Re: 31 Crosland Edge, Meltham, Huddersfield HD9 5RS

Please accept the following clarification and comment regarding the above planning permission.

GROUND FLOOR PLAN_
AS PROPOSED_

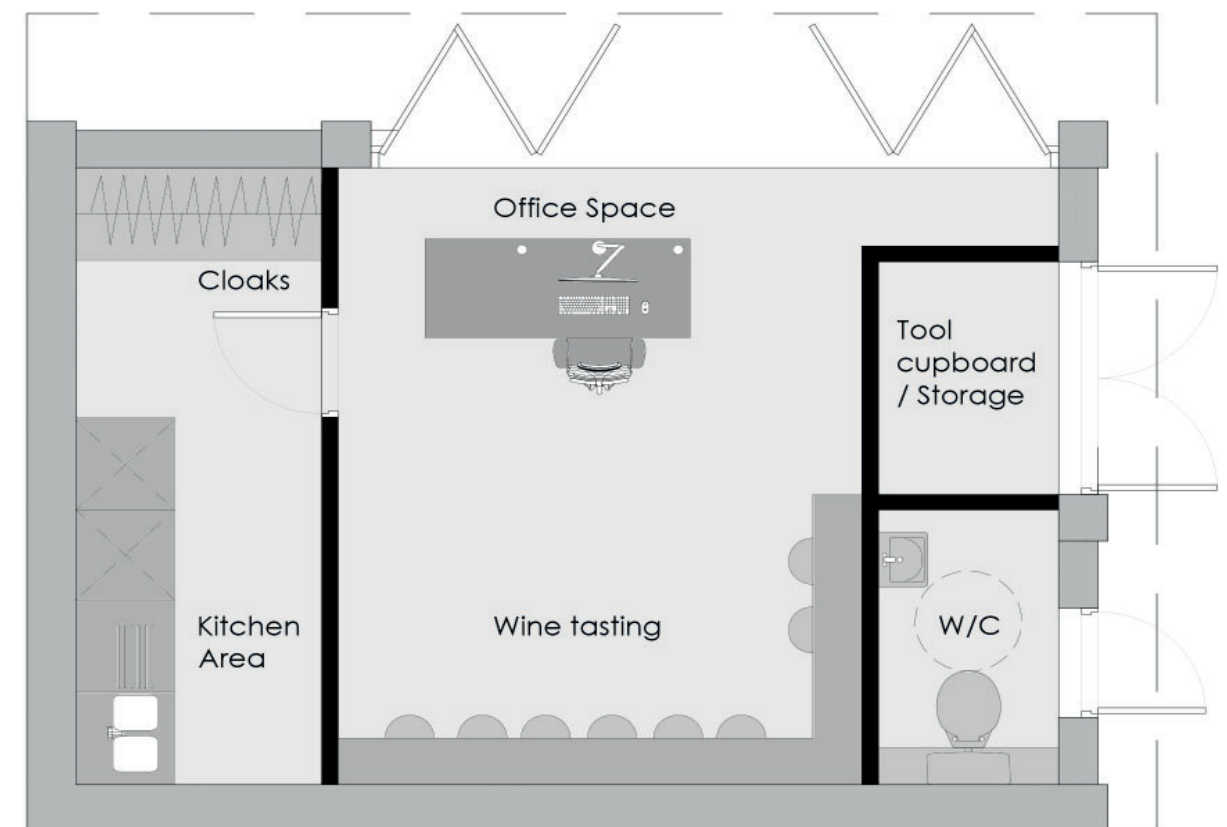
The proposal and design at 31 Crosland Edge suggest the primary and principal use of the proposed building (based on size, dimensions and design) is for wine tours and tasting and the management of the administration relating to this hospitality business only; the Design and Access Statement accompanying the application indicates that the facility centre would include the following:

- The office space would be used to manage the appointment booking rather than the agricultural aspects.
- The building design is not what is typically found in agricultural buildings in the Valleys and is clearly designed to support wine tasting and tours in an attractive setting, with the option to evolve the hospitality aspect further.

The tours and associated facilities form a significant element of the proposed development both in terms of the floor area they occupy and the nature of the proposed building use, they are not “*ancillary to normal farming activities*”. The Design and Access statement accompanying the application recognises the importance of the visitor centre in terms of the success of the overall business proposal, with the applicant perceiving an increased demand for wine tours and wine tasting, which dictate the need for the artfully designed building.

It is fairly easy for any application to be supported by statements of what they will do or, indeed, evidence of processing equipment on site, but the site design and quality of build tend to be a good indication of what the actual use of the property will be. A high specification of design and features such as the canopy are designed to enhance the experience of customers, not support the processing and storing of the product; the building is for hospitality, not wholly agricultural purposes.

Drawing Title: AS PROPOSED, SITE SECTIONS / CONTEXT ELEVATIONS

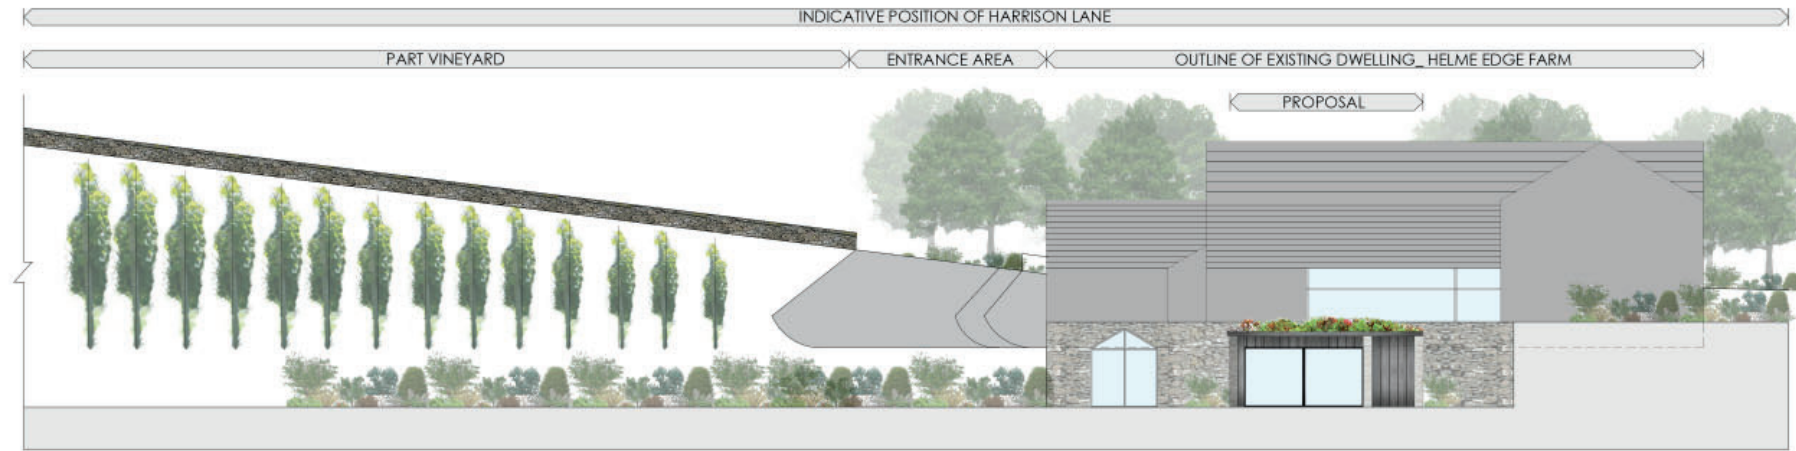
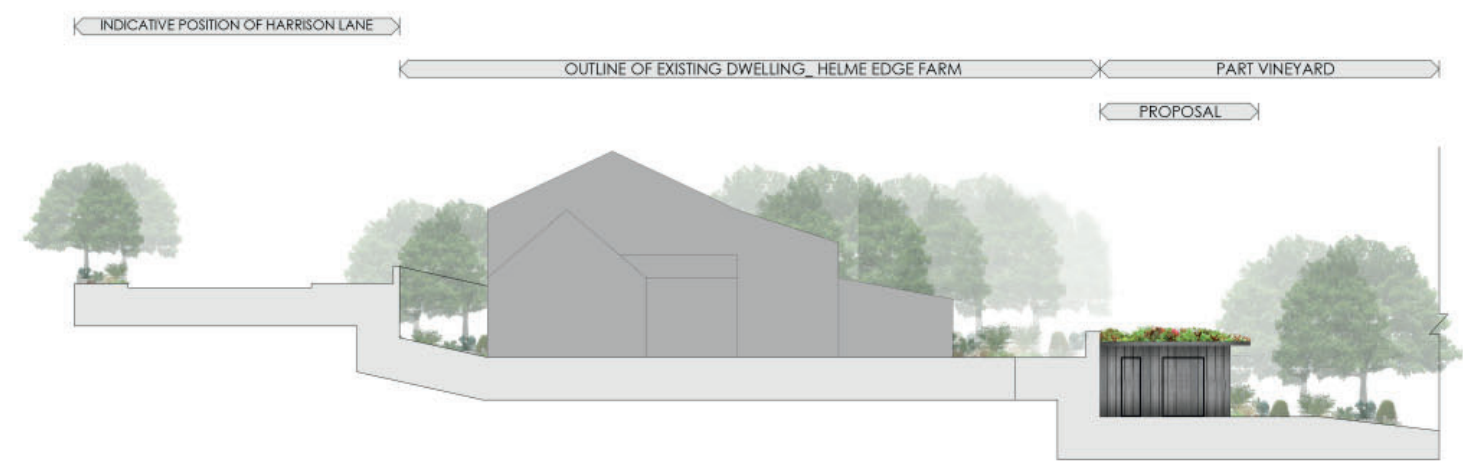
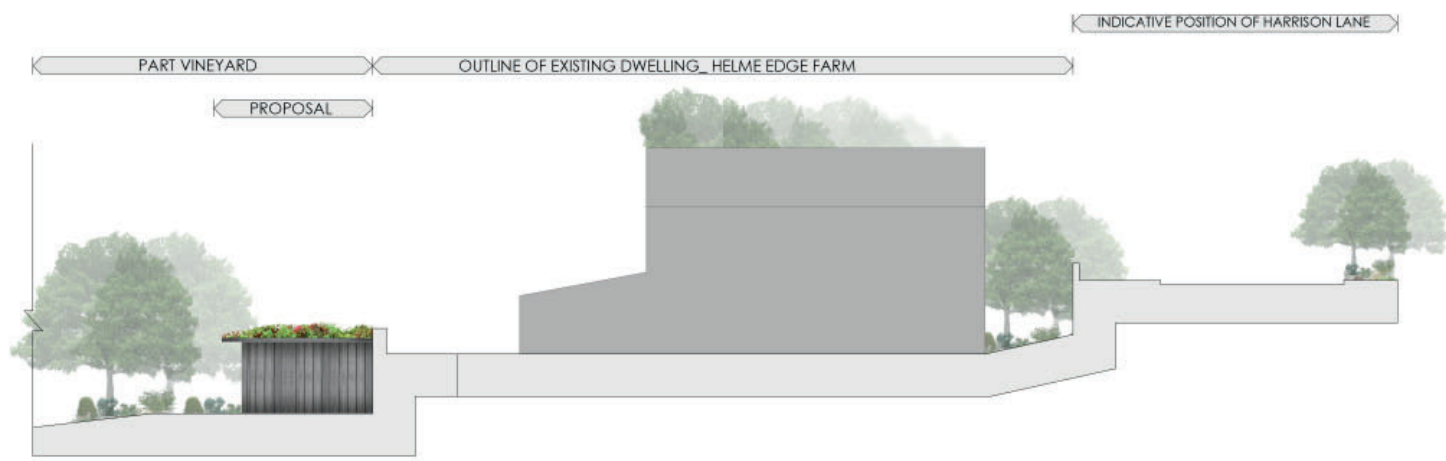
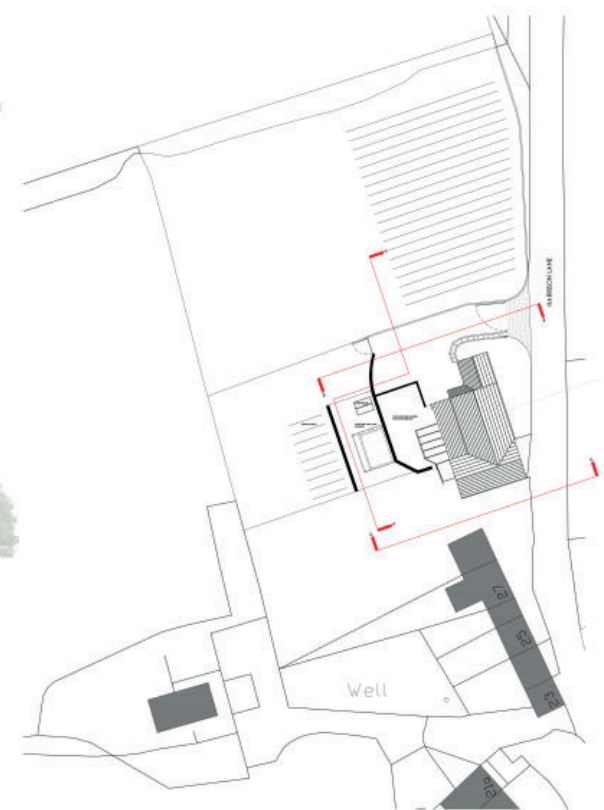
Given the size of the footprint, volume and height of the proposed building, it would certainly impact on the openness of the Green Belt. This would comprise a significant development located within an area that is predominantly undeveloped but co-located with an established residential area and very close to neighbouring buildings that will lose amenities.

The proposed location is a sensitive site, being visible from a conservation village, many footpaths and the public highway. In its immediate setting, being co-located with family homes, it is inappropriate and will result in a loss of amenity for local residents enjoying what is a tranquil and sensitive area. The immediate location, together with the number and occurrence of tours and wine tasting, will generate noise and nuisance to the neighbouring properties.

Drawing Title: AS PROPOSED, PART SITE PLAN

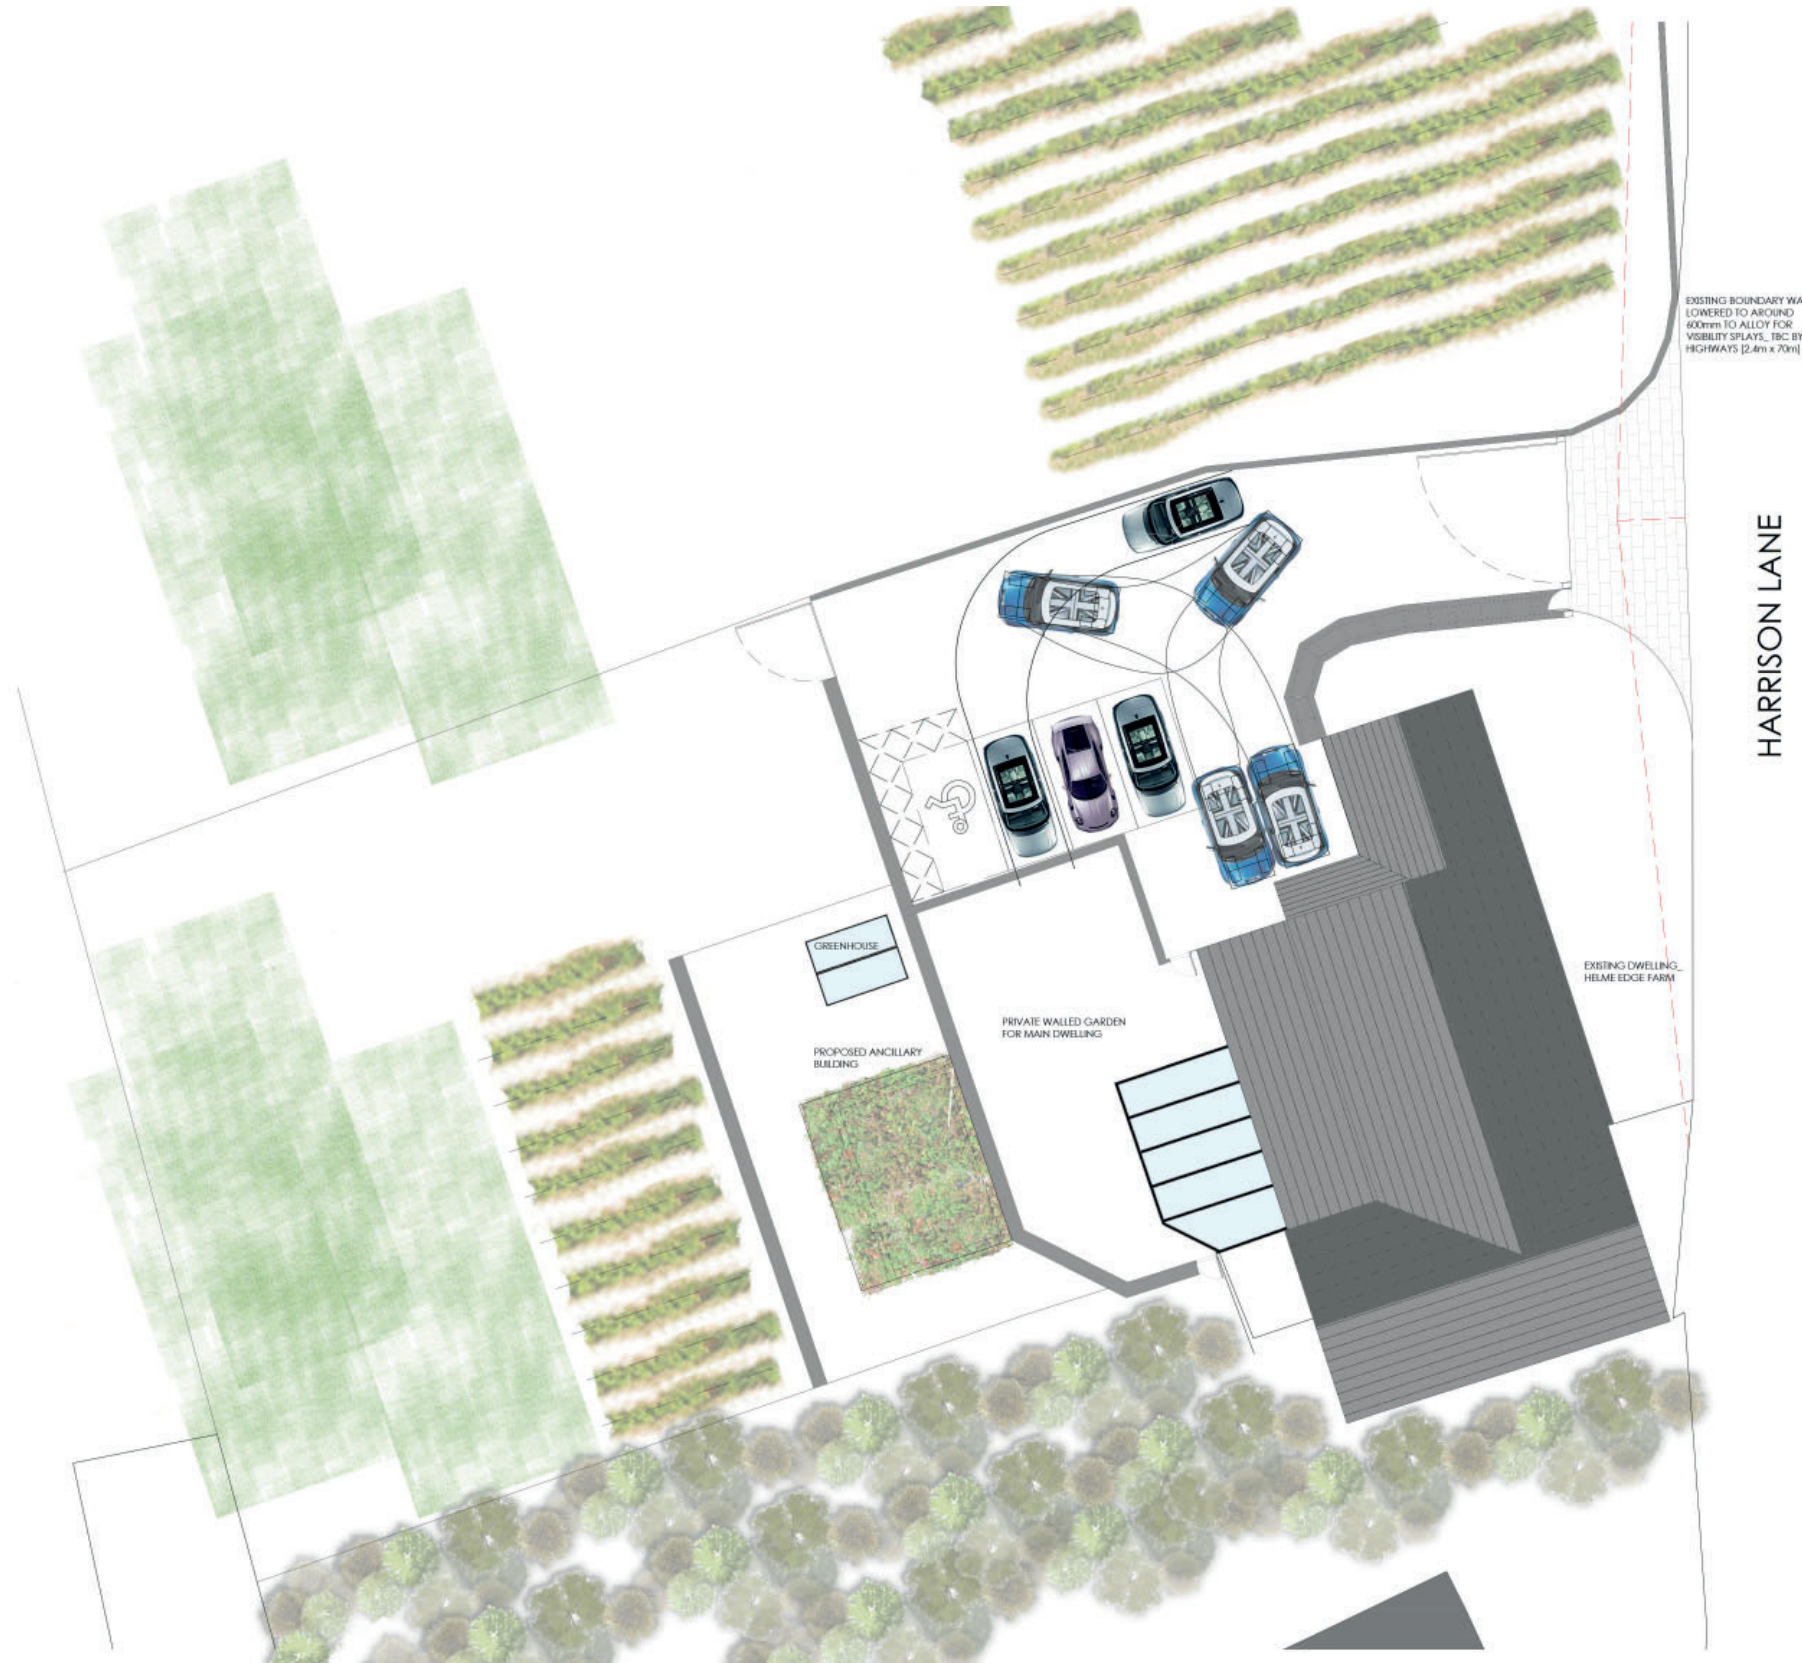
The design of the canopy increases its footprint and will encourage people to dwell increasing the nuisance. If, the purpose of the canopy is for shading, why not a brise solieu which will have the same outcome, with a smaller footprint and will not encourage outside dwelling.
